**Consultation Response from KC,  
Highways Development Management**

**2024/90255 Land Off, Burn Road, Birchencliffe, Huddersfield, HD3 3BT**

**Reserved matters application, including the considerations of appearance, landscape, layout, and scale for the erection of 26 dwellings pursuant to outline permission 2019/94051 (outline application of up to 39 dwellings and associated works), discharge of conditions 27 (Arboriculture Assessment), 28 (Ecological Assessment), 29 (Public Right of Way)**

**Date Responded: 7-5-2024.**

DRAWING TITLE
VEHICLE TRACKING DRAWING

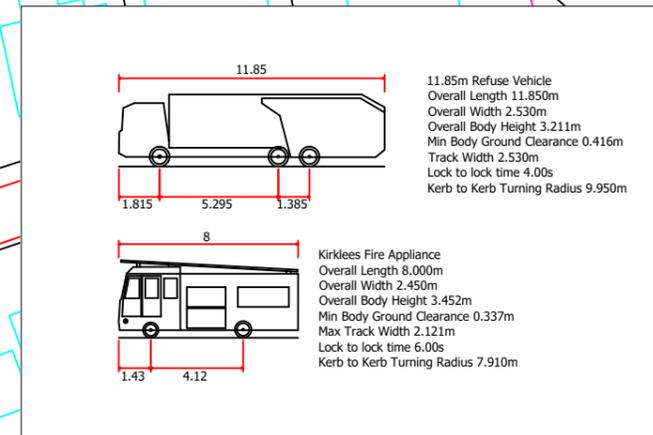
2, Swept paths should be provided which demonstrate that an 11.85m refuse vehicle can enter and exit the site from Burn Road and turn within the site. All schemes must incorporate reasonable tolerances and safety margins. A good starting point is to allow 0.5m clearance to kerbing or vertical obstructions on each side of the swept path. Designs should therefore, where possible, aim to cater for vehicles larger than the above minimum standards.

1, The access road turning head must be increased from plot no. 16 to plot no. 14 to reduce the bin carry distance.

2, The turning head near plot no. 26 needs to be increased in size to ensure it is effective.
